## **Stage 2 – Martin Place North (SSD 9270) and South Sites (SSD 9326) Over Station Developments**

Thank you for your correspondence dated 8 October 2018 which invites the City of Sydney ("the City") to provide comment on State Significant Development (SSD) Applications 9270 and 9326.

The City has reviewed the stage 2 detailed applications for over station tower developments and based on the submitted information **objects** to the proposals in their current forms.

Outline of shadow cast by North Site  
Stage 1 SSD DA building envelope

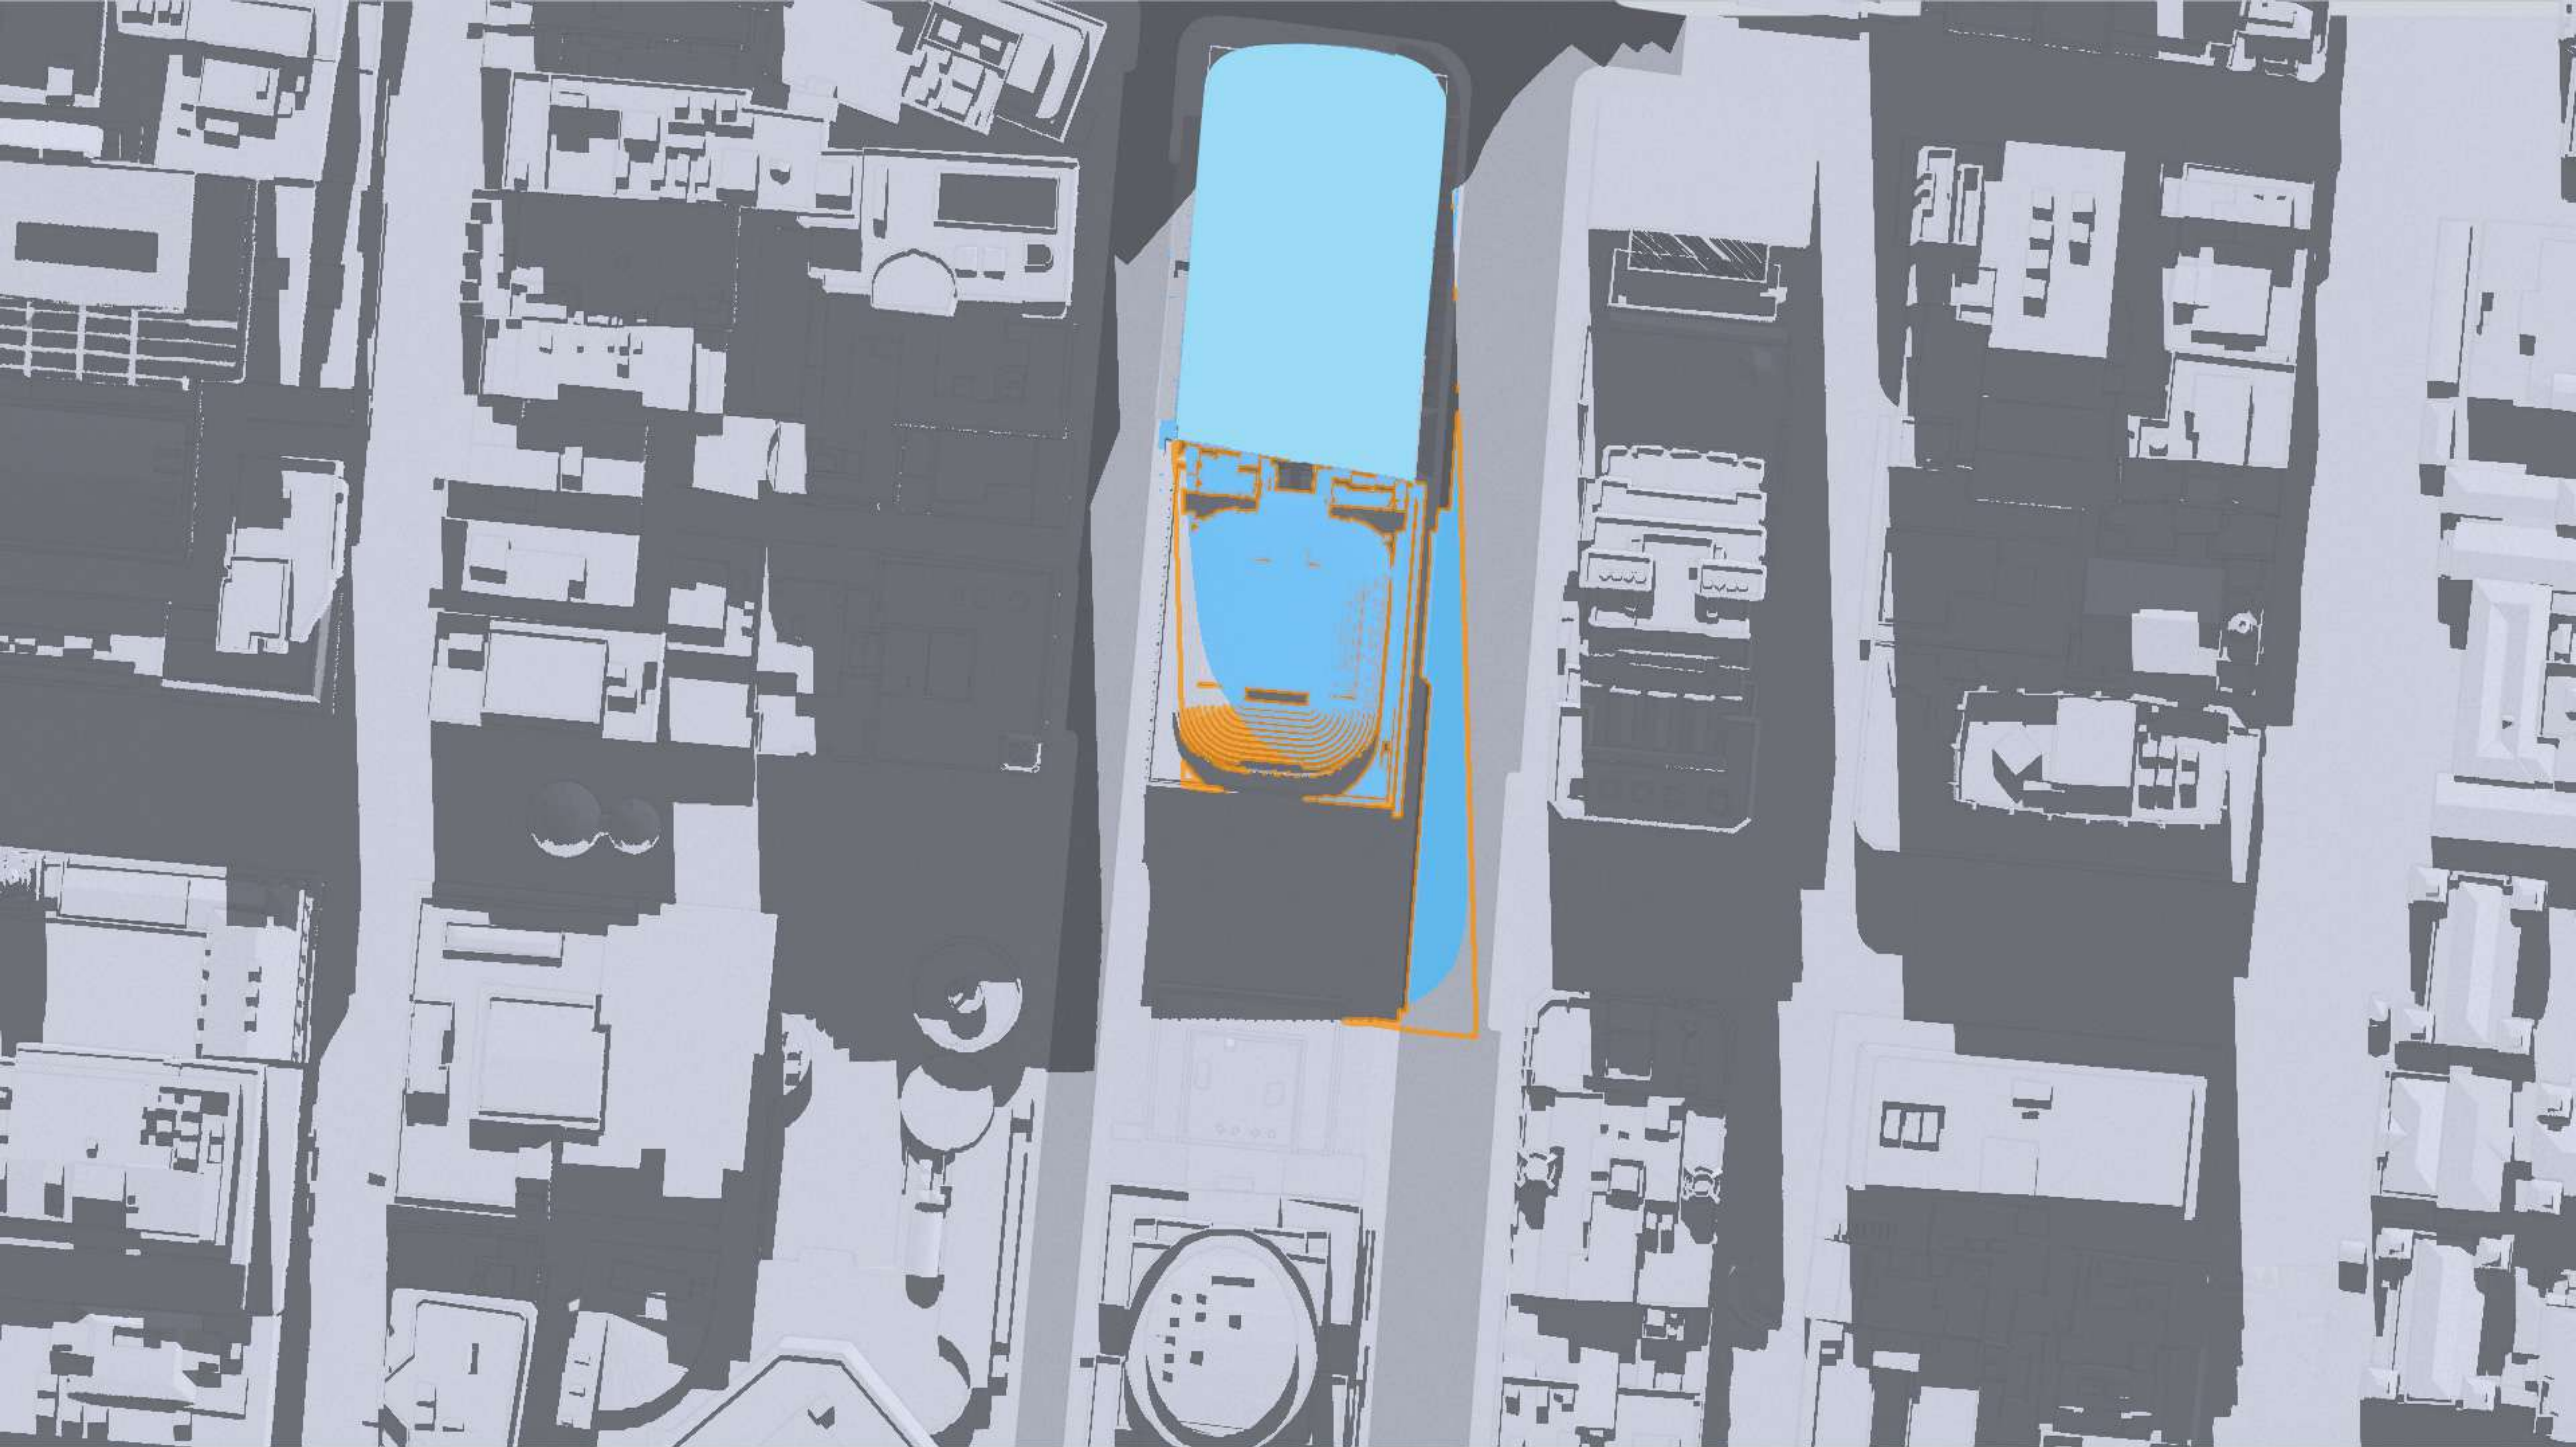
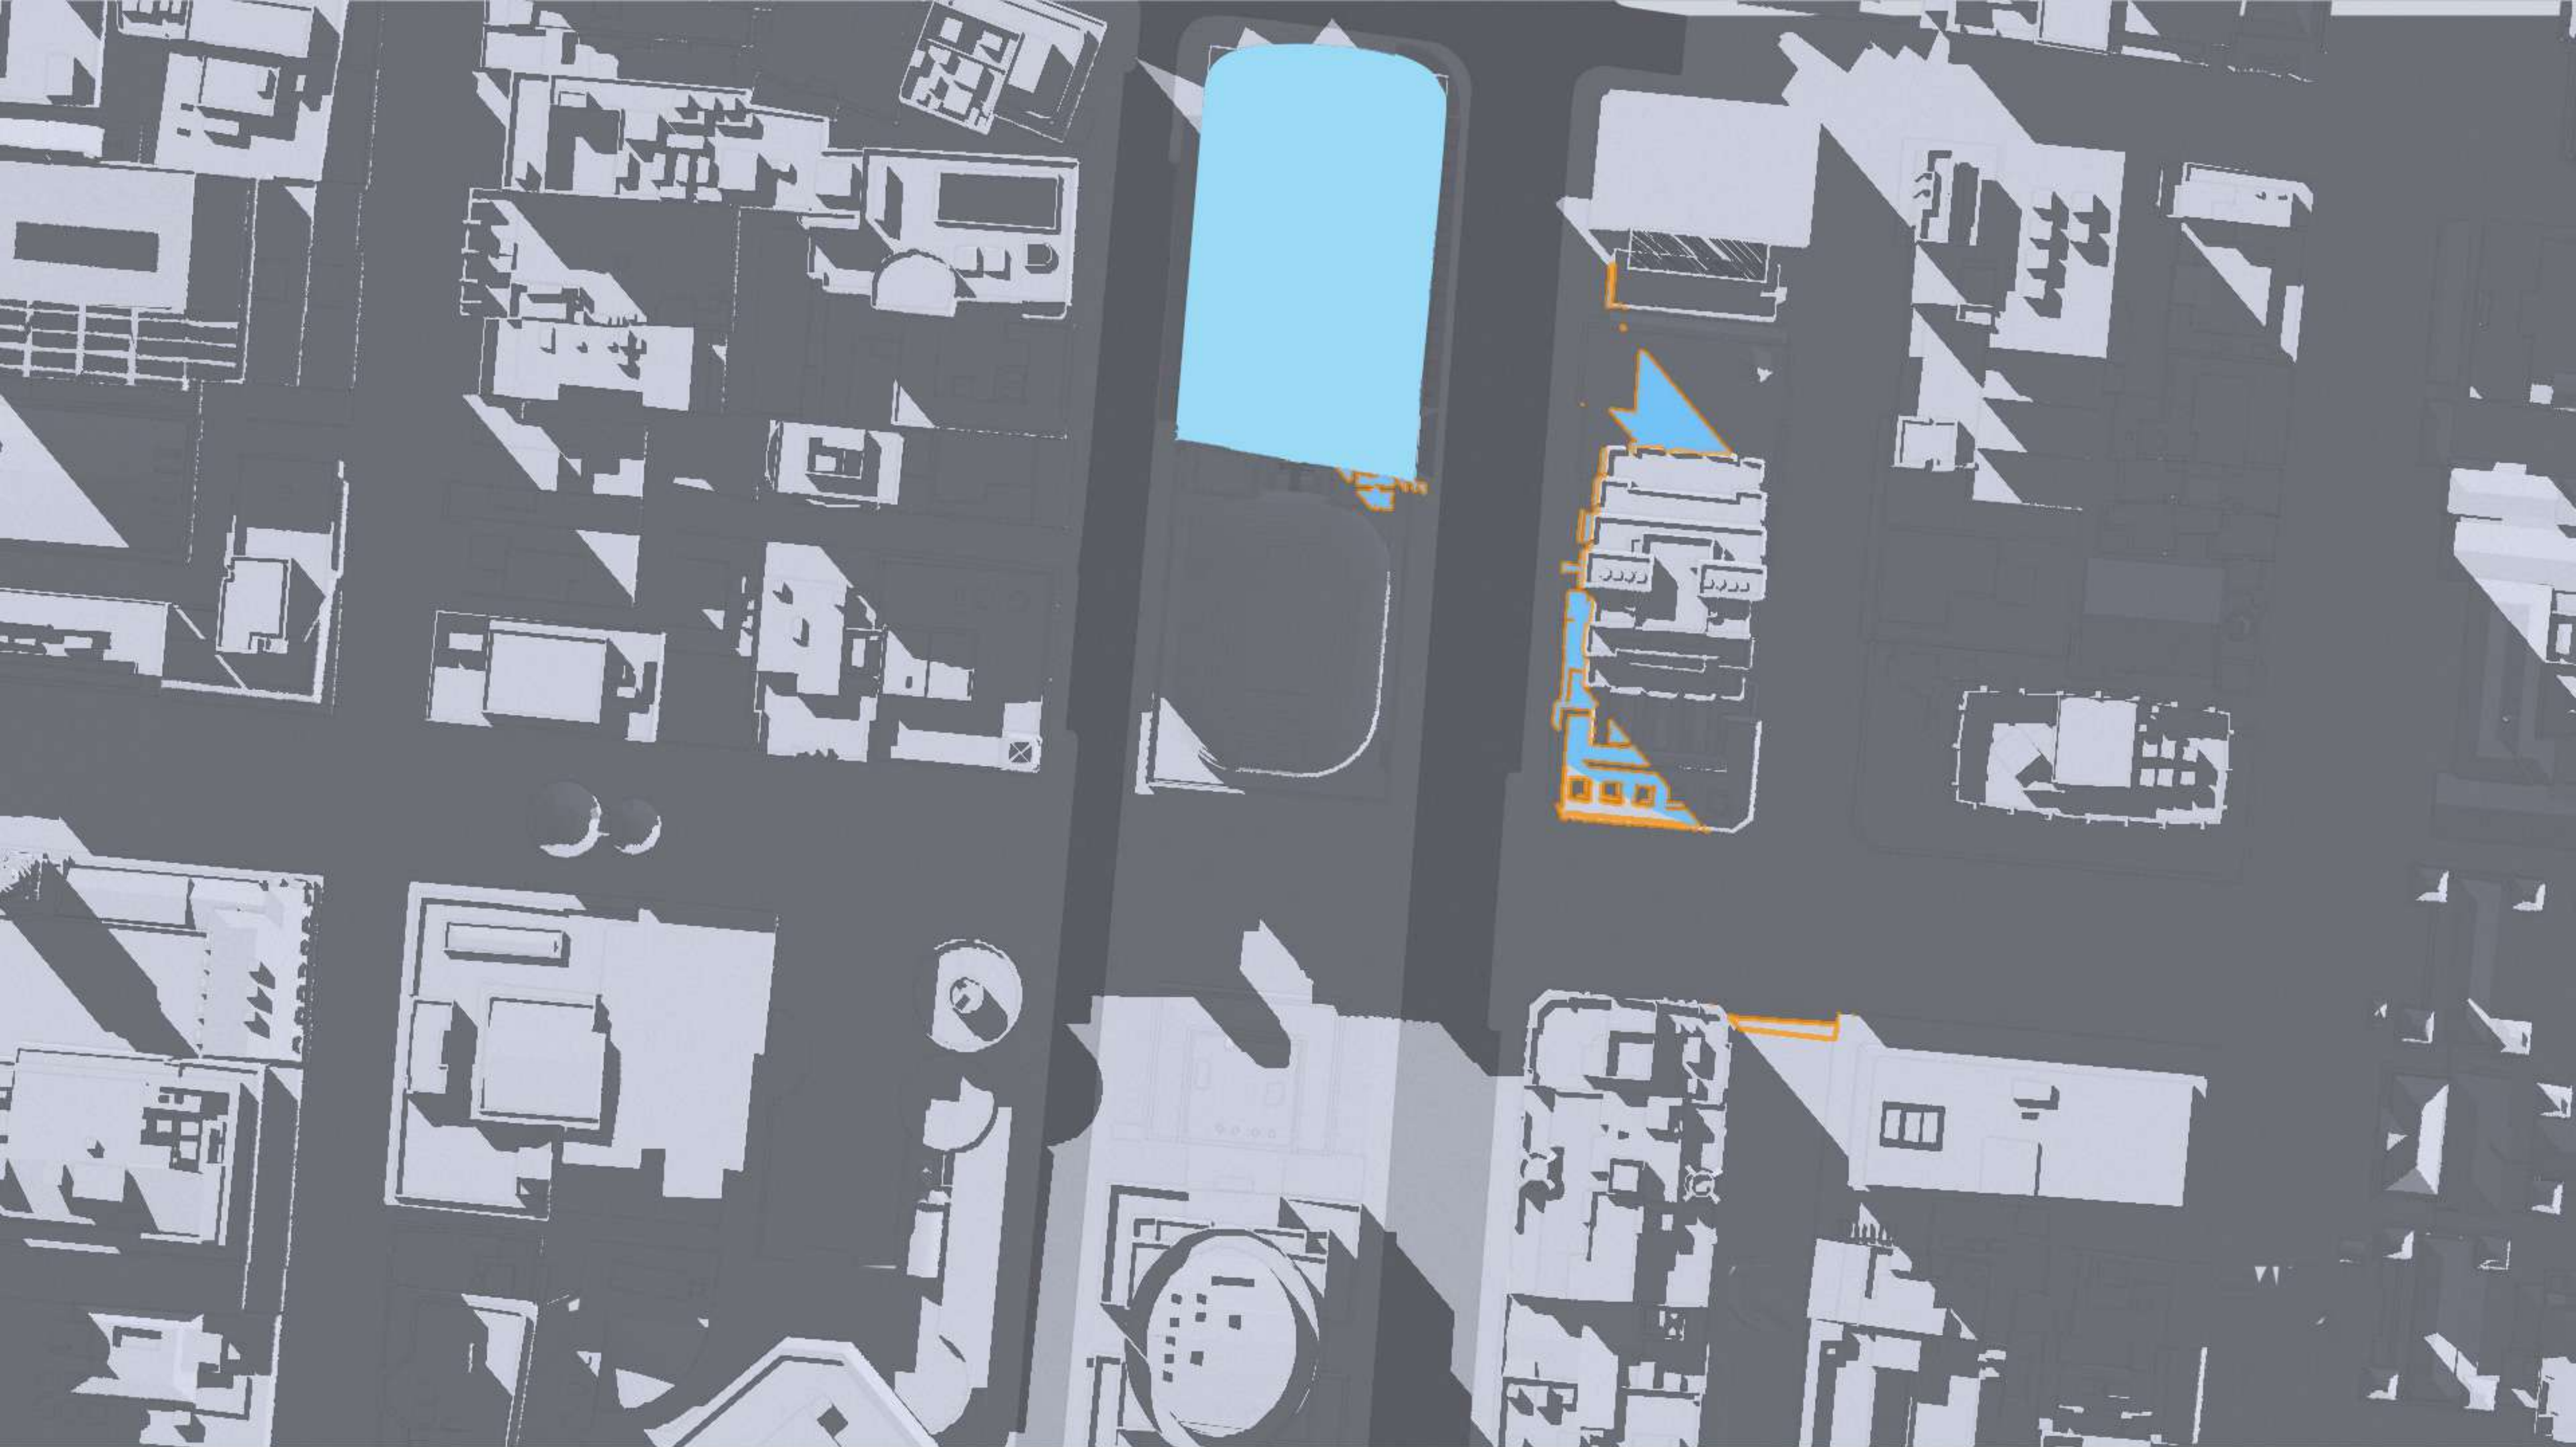
The proposed building form of the north tower is incongruous to the character of central Sydney and the Martin Place Special Character area. The City recommends that the northern tower be setback by at least 8m from all street frontages above the podium height of 50 Martin Place. In particular a setback above the podium is essential for Elizabeth Street frontage to address overshadowing of Martin Place which is avoidable.
